**Re: Response to Submissions and Amended Plans for SSD 6847 - Sutherland Hospital Redevelopment**

Below is a list of the amended architectural drawings at Attachment 5 and corresponding amendments:

1 SECTION 1
1:200

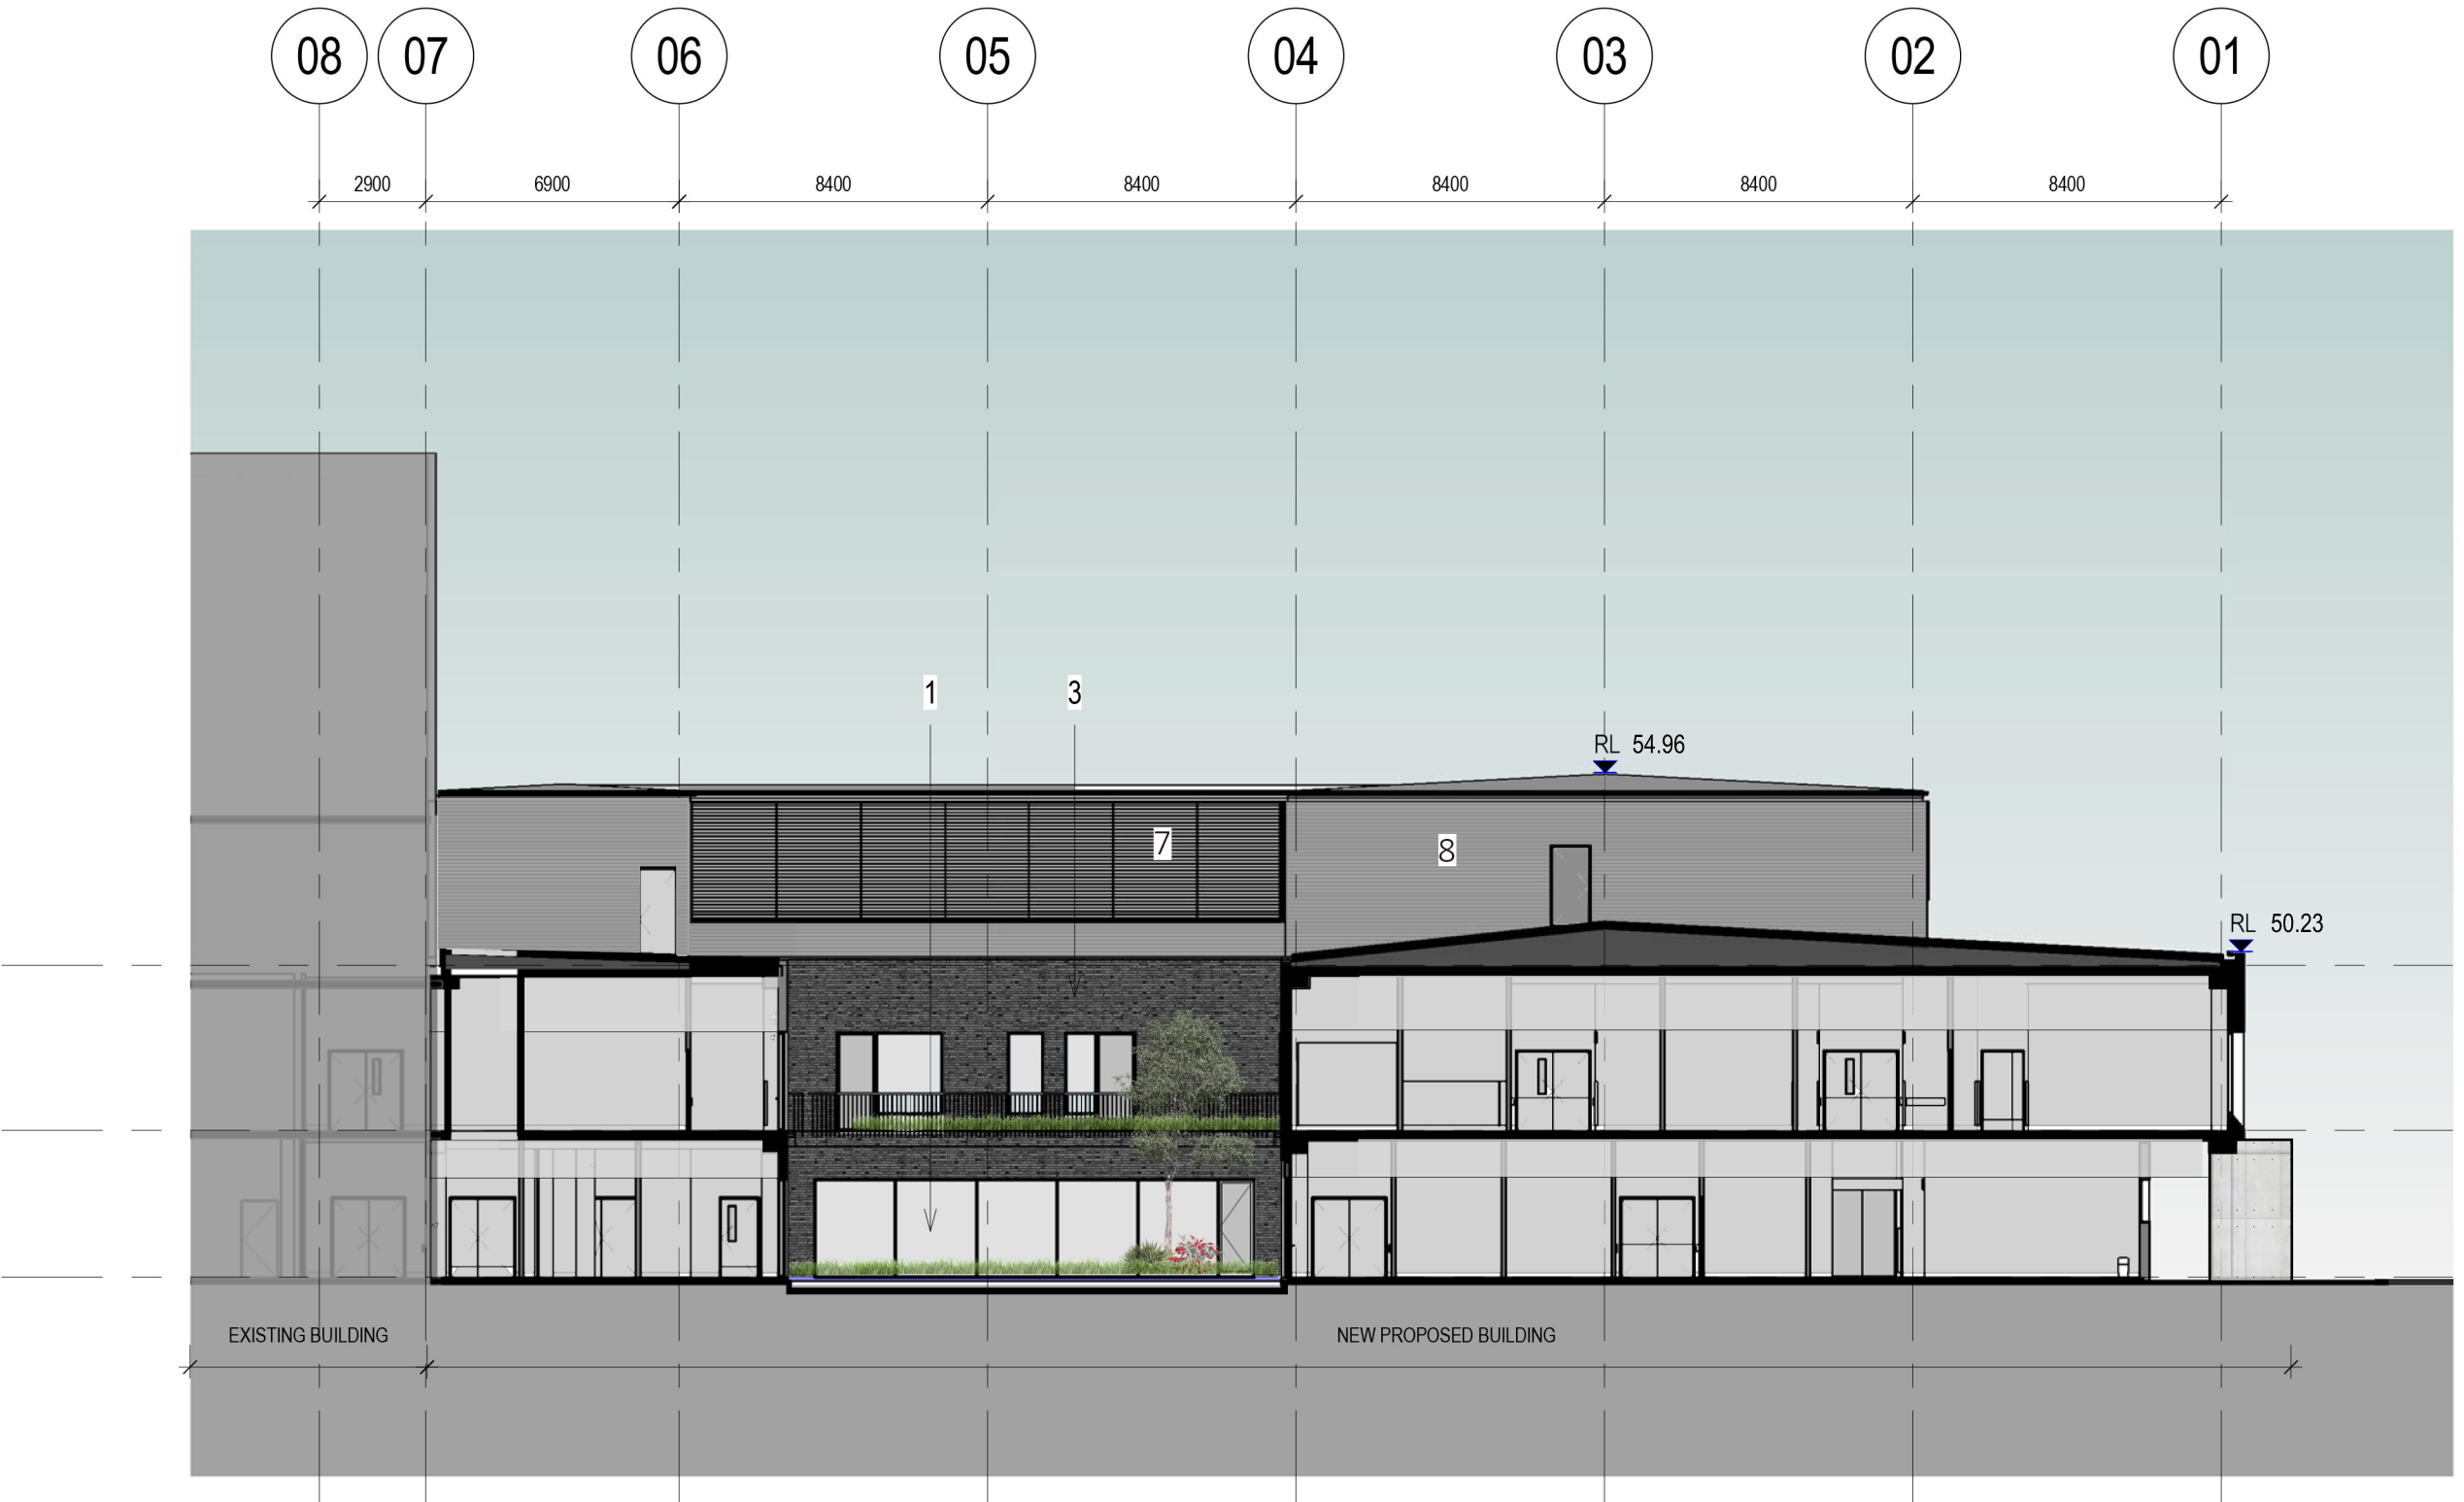
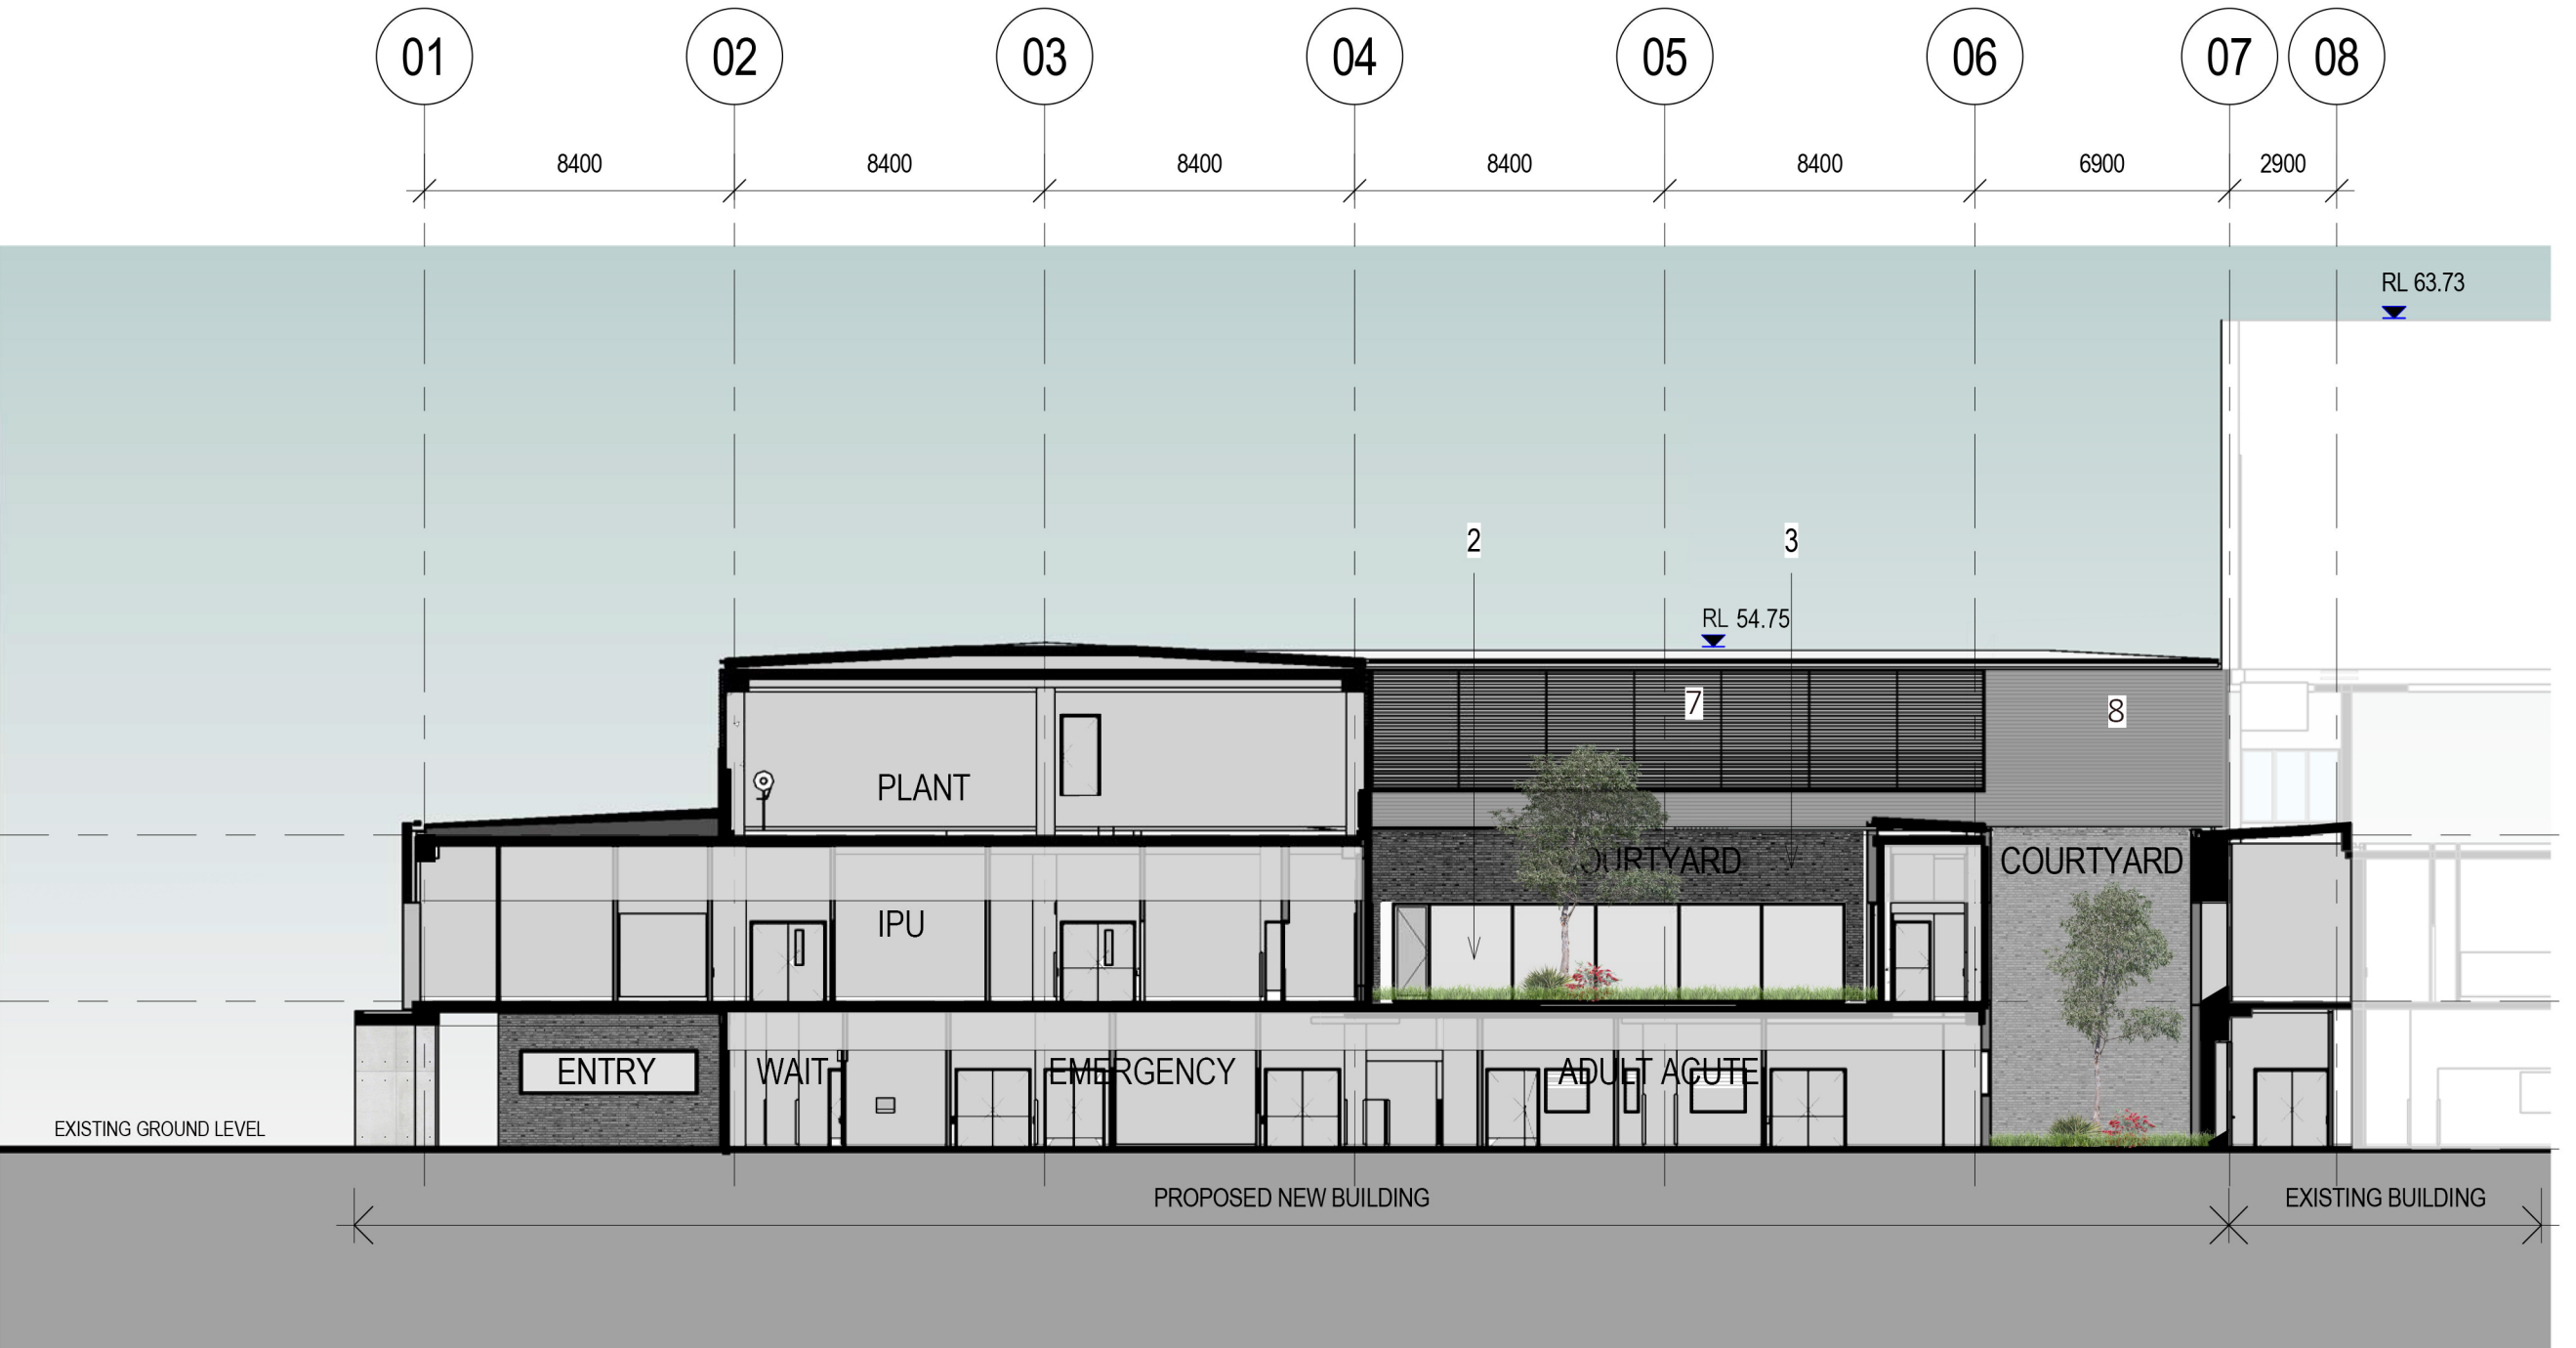
| <b>A-SHP-DA-D01 (3)</b> | <ul style="list-style-type: none"> <li>Concrete stair cores amended from RL 54.03 to RL 54.50</li> <li>Ridge line of plant amended from RL 53.03 to RL 54.96</li> <li>Plant Room enclosed on from GL 04-06 on Section 2</li> <li>Plant Room enclosed on from GL 04-06 on Section 3</li> <li>Courtyard façade treatment amended in all sections to demonstrate amendment from cladding panels to a face brick façade</li> <li>Section 4 updated to indicate retention of the existing façade</li> </ul> |

1 WEST ELEVATION
1:200

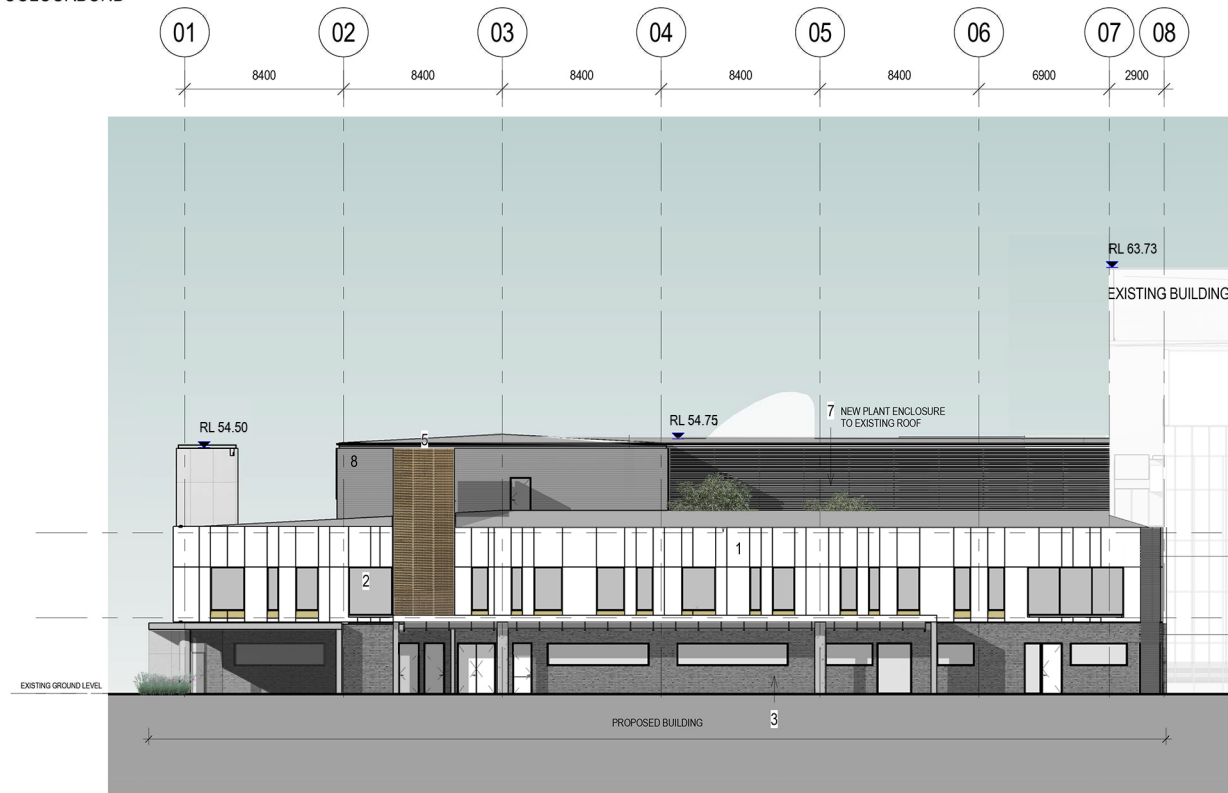
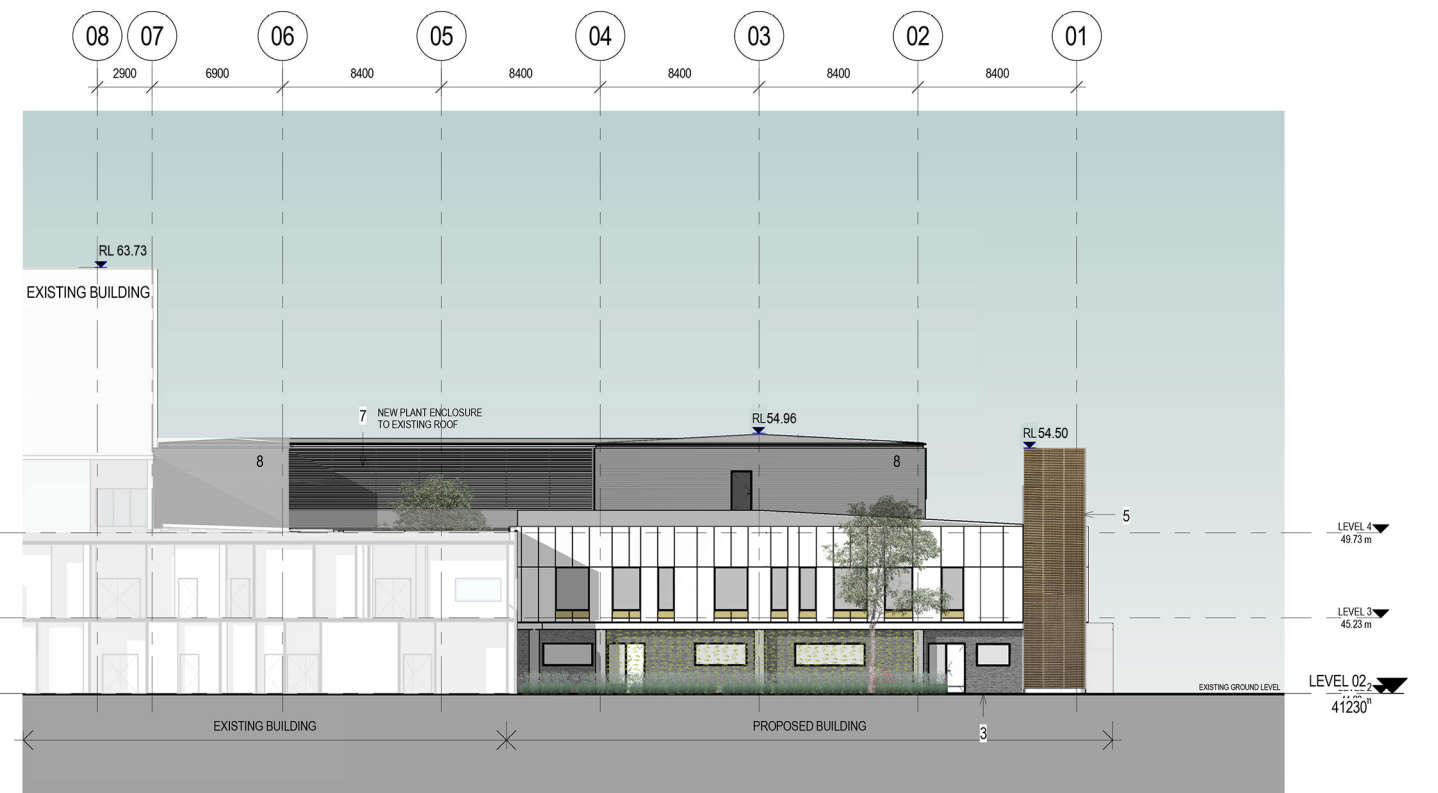
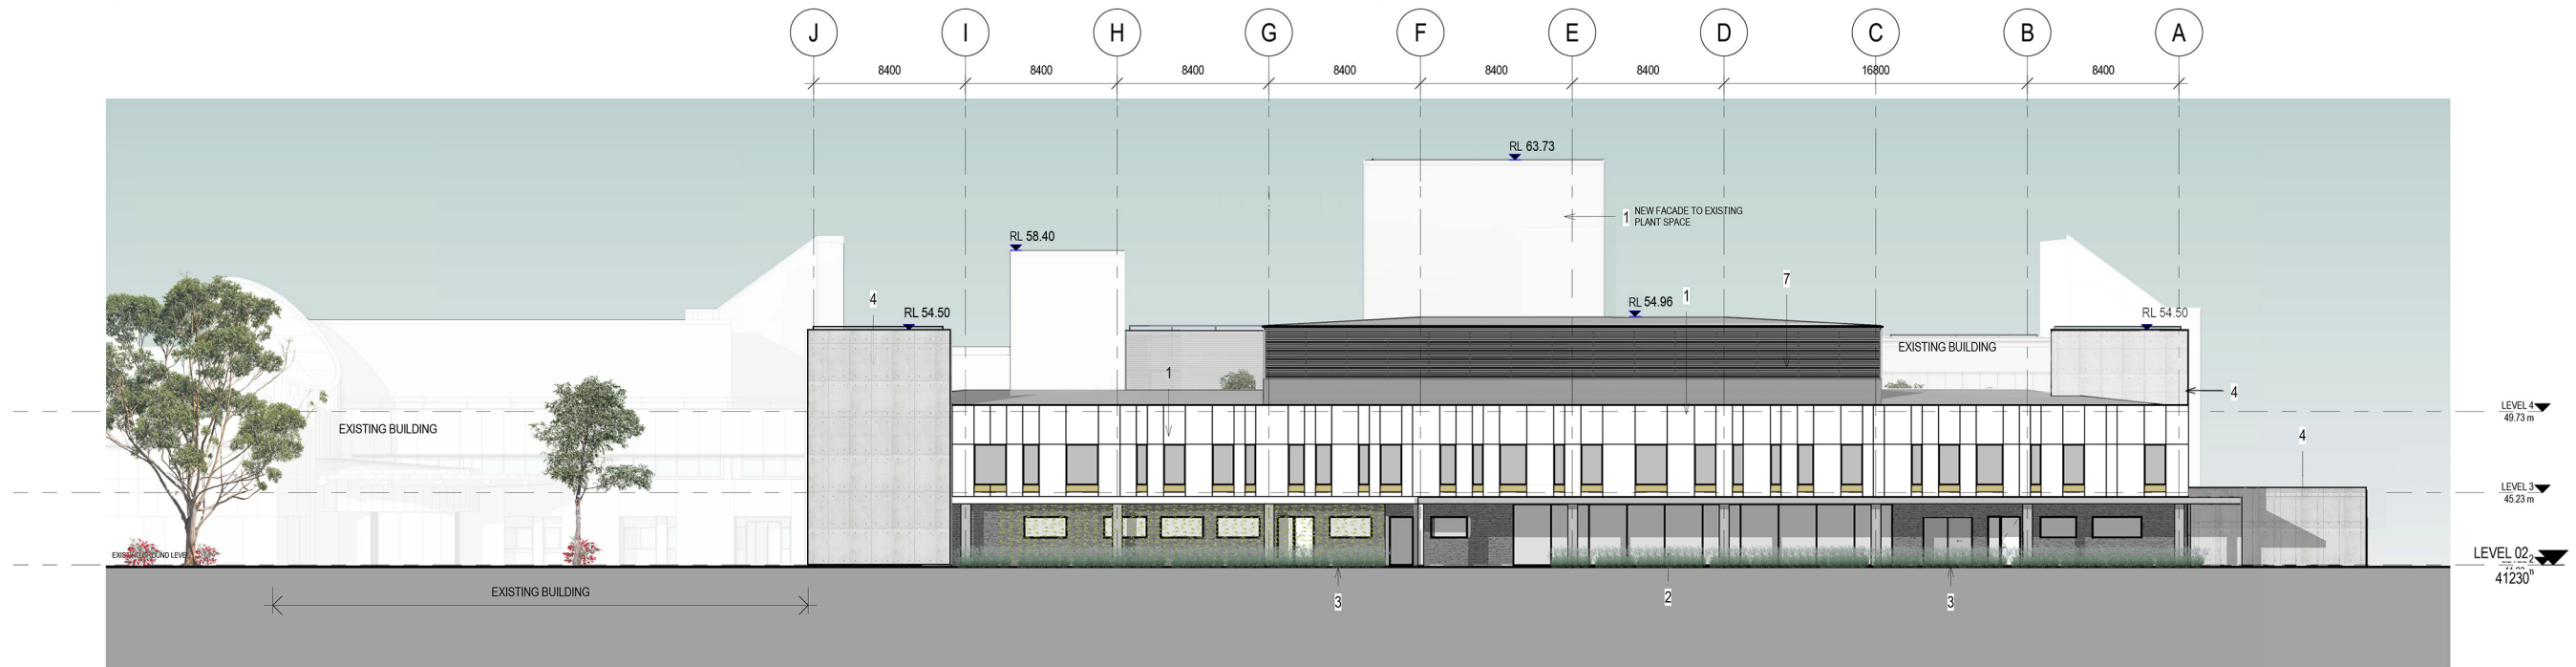
| Drawing                                        | Proposed Amendment                                                                                                                                                                                                                                                                                                                                                                    |
|------------------------------------------------|---------------------------------------------------------------------------------------------------------------------------------------------------------------------------------------------------------------------------------------------------------------------------------------------------------------------------------------------------------------------------------------|
| <b>A-SHP-DA-C01 (4)</b>                        | <ul style="list-style-type: none"> <li>• Concrete stair cores amended from RL 53.03 to RL 54.50</li> <li>• Ridge line of plant amended from RL 53.03 to RL 54.96</li> <li>• Plant Room enclosed on from GL 04-06 on West Elevation</li> <li>• Plant Room enclosed on from GL 04-06 on East Elevation</li> <li>• The new plant proposed on the existing roof is deleted and</li> </ul> |
